From: Martyn White
Sent: 24 June 2019 12:22
To: Planning.Responses
Cc: Anita Gardner
Subject: AB/48/19/PL & AB/49/19/L

AB/48/19/PL & AB/49/19/L

Listed building consent for internal and external alterations to facilitate the change of use of upper floors to a single, four bedroomed residential unit [use class C3a] and ground floor to a commercial unit (use classes A1,A2 & B1a).

terrier firma

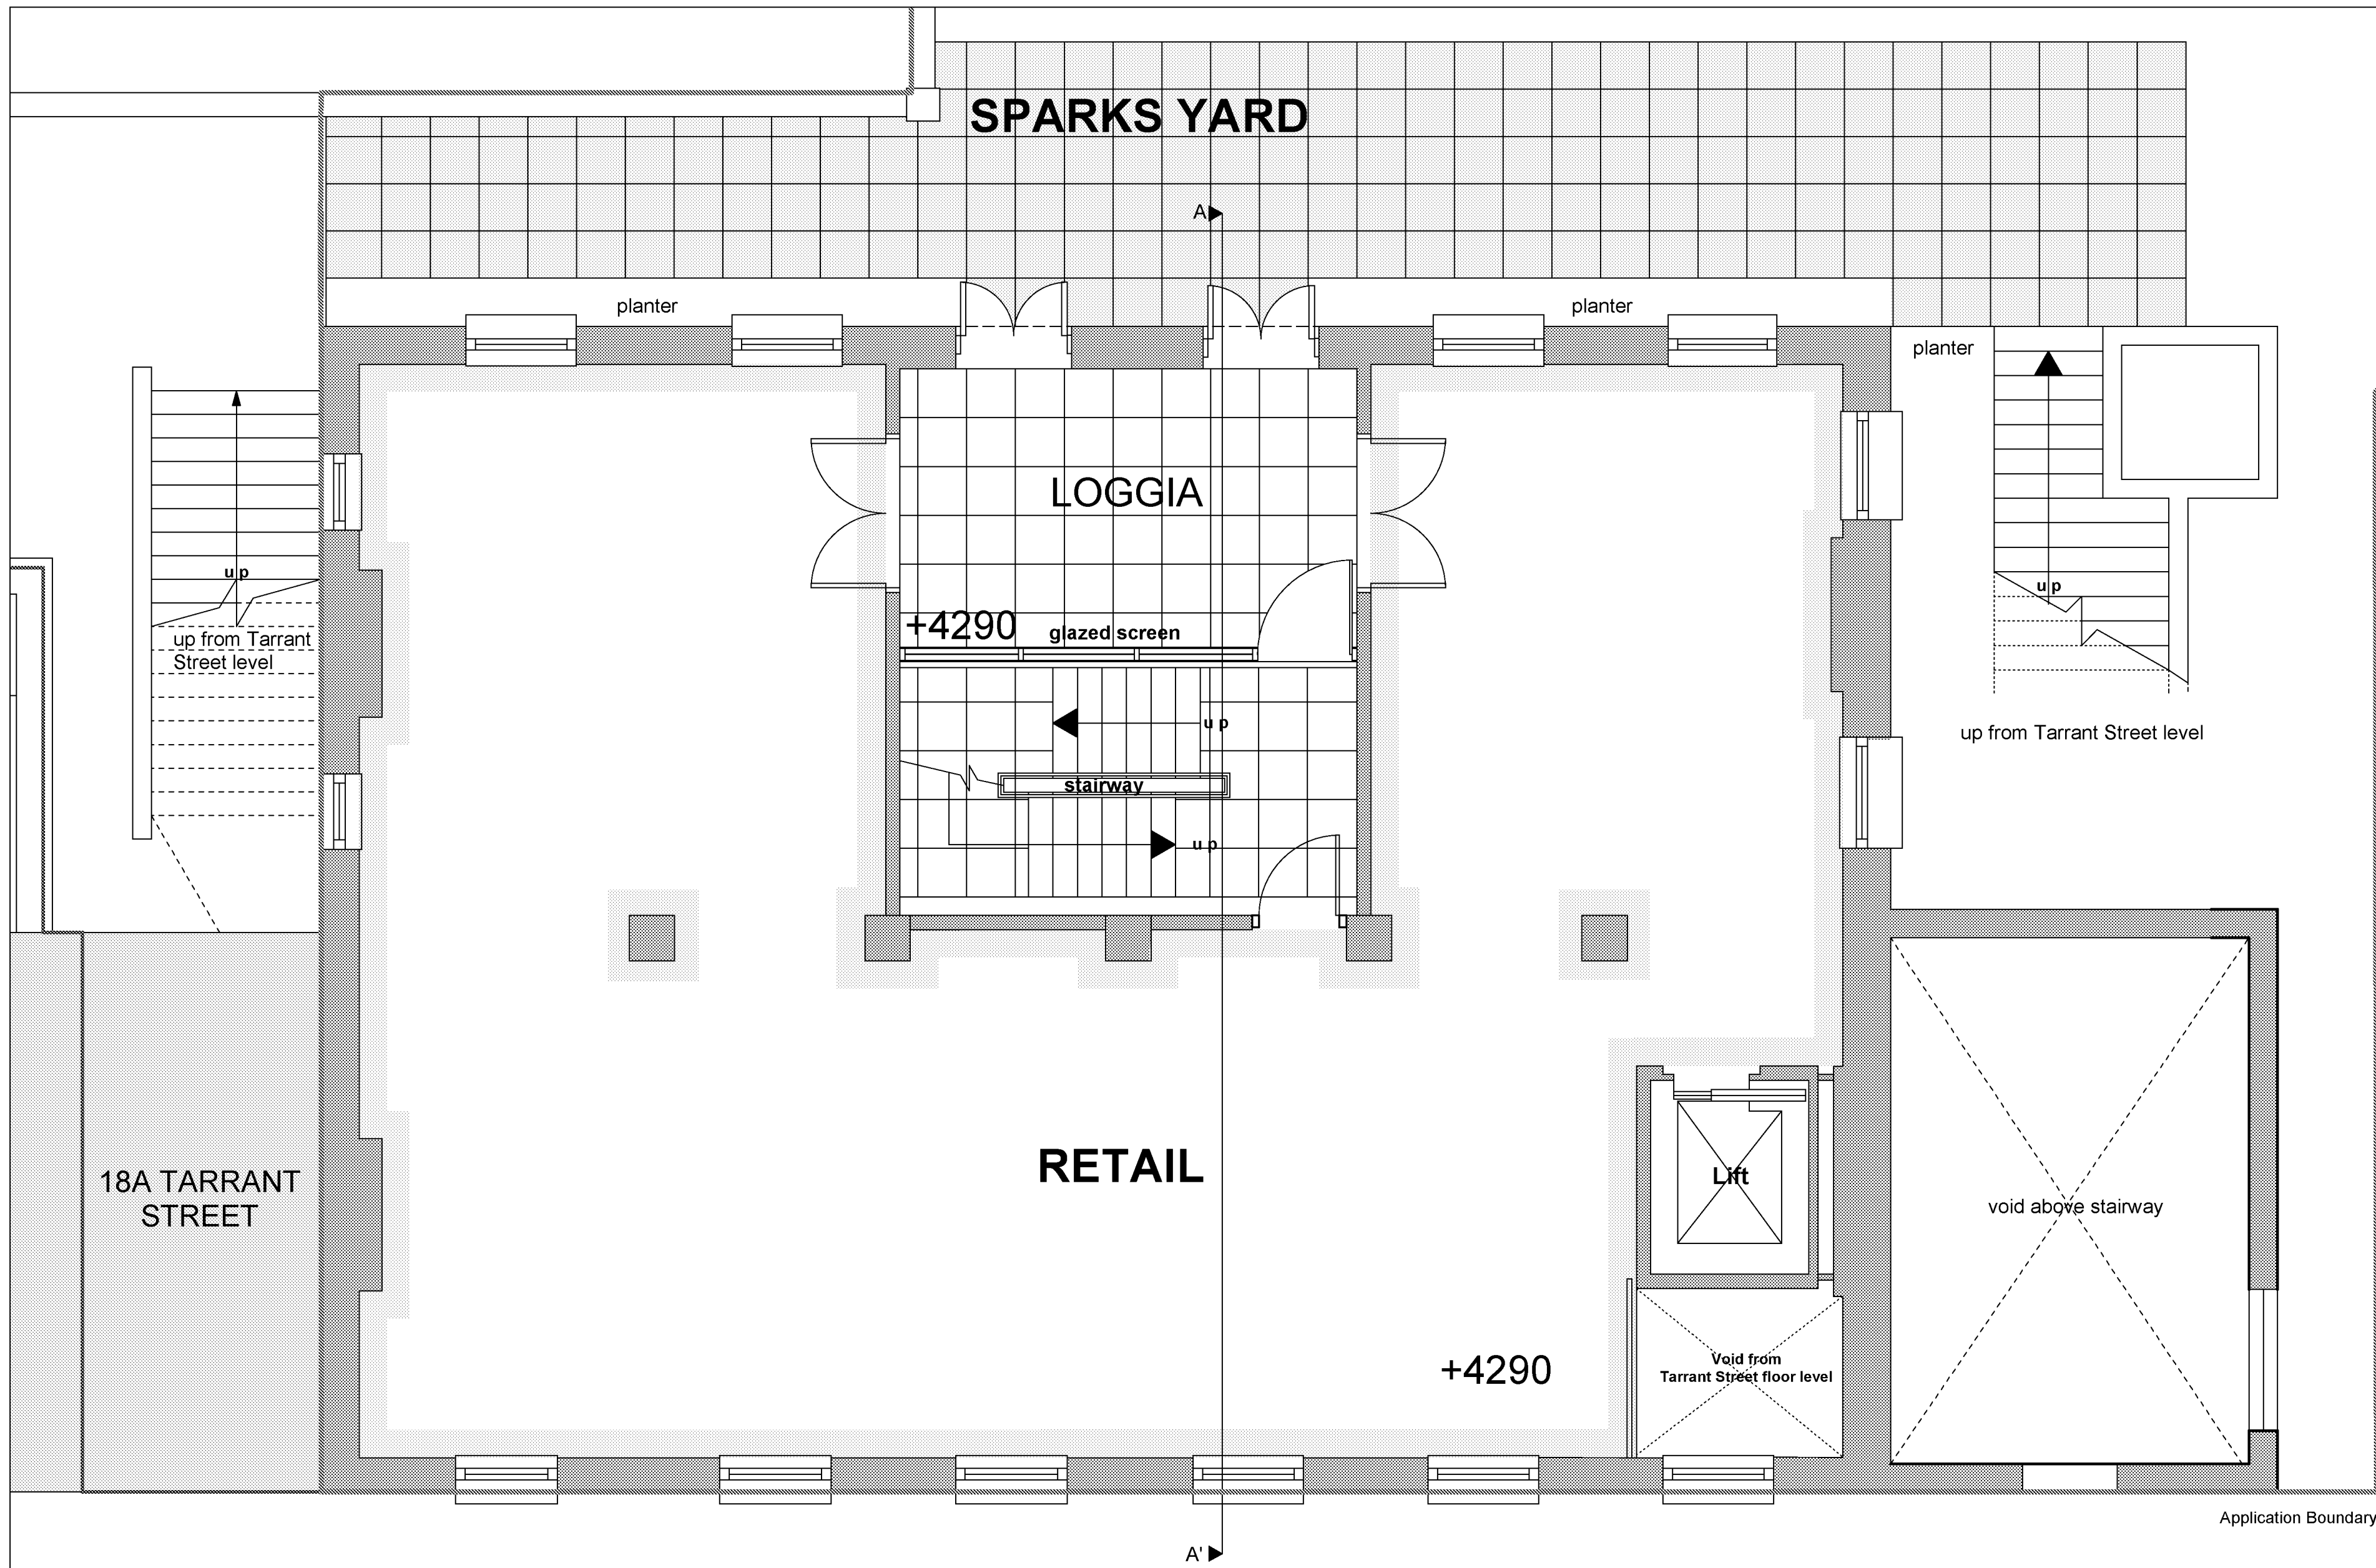
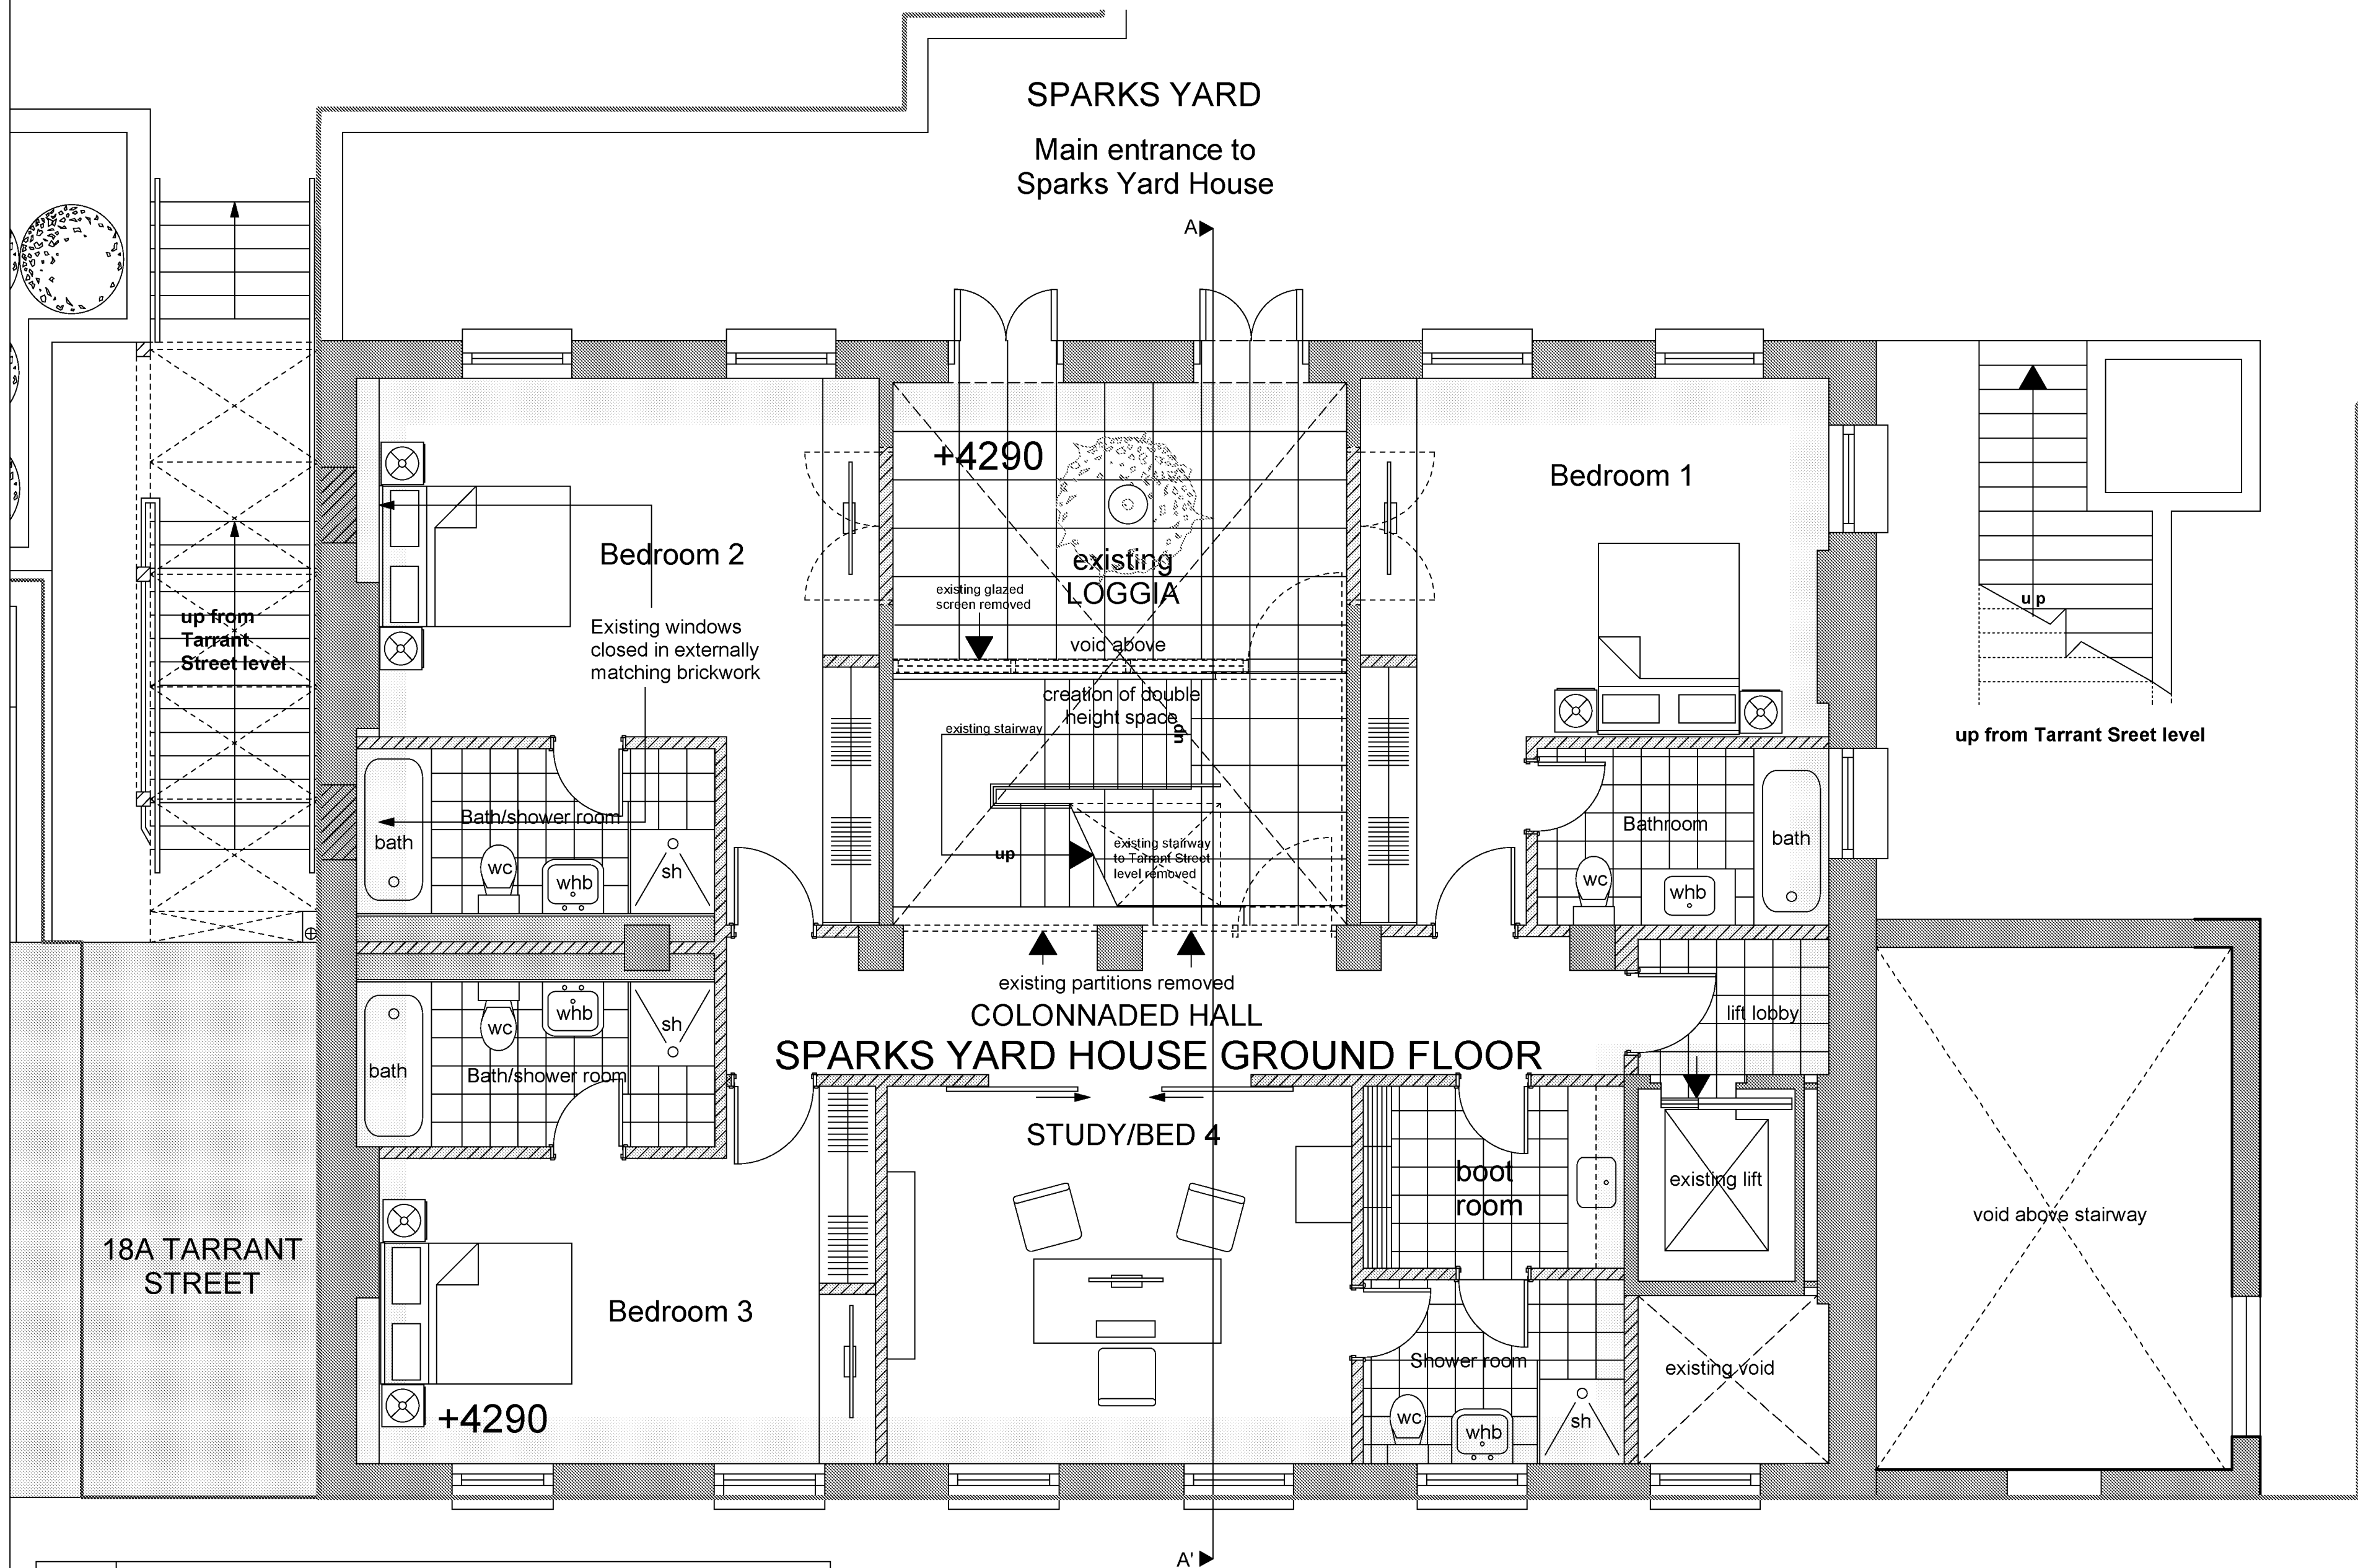
The only concern relates to the proposal to cover internal brick walling with plasterboard. I note that reference is made to the fact that the brick walling will be left exposed if possible. However, covering up a significant amount of the brick work will negatively affect the character of the building. Such an issue should be reconsidered.

**PROPOSED WEST
ELEVATION**

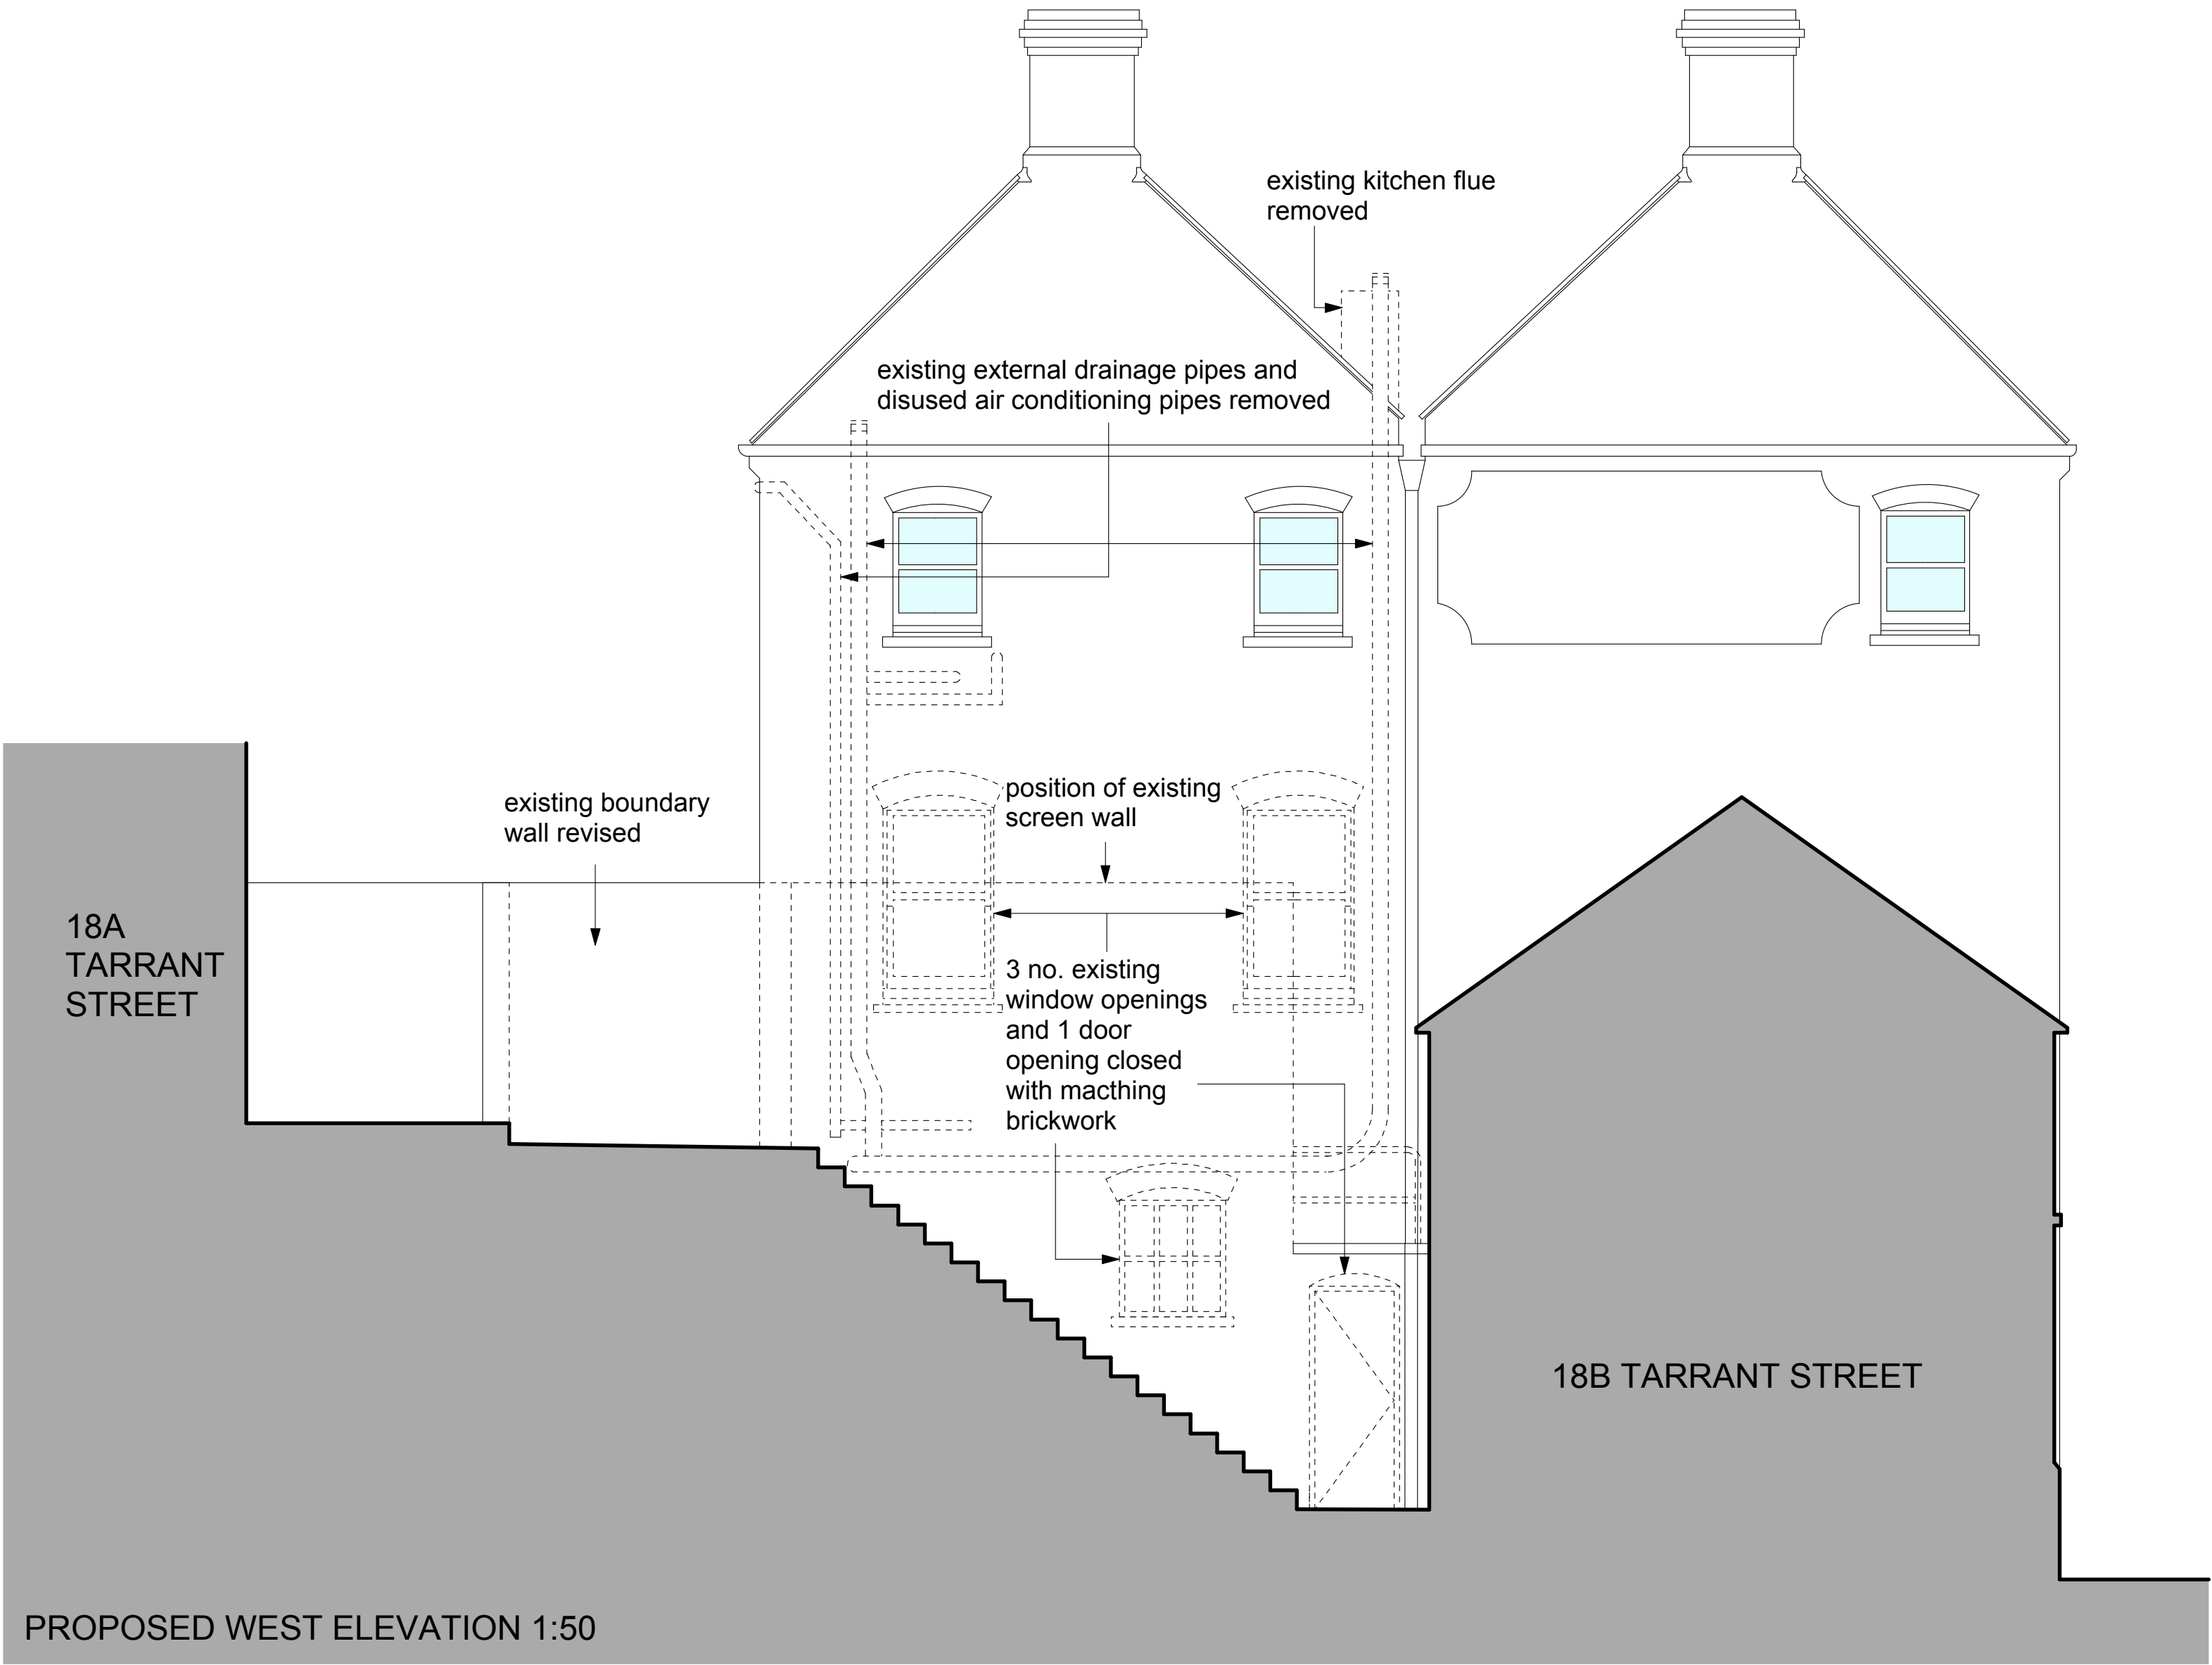
The removal of all extraneous drainage pipework from the western elevation will have a positive impact upon the appearance of the building.
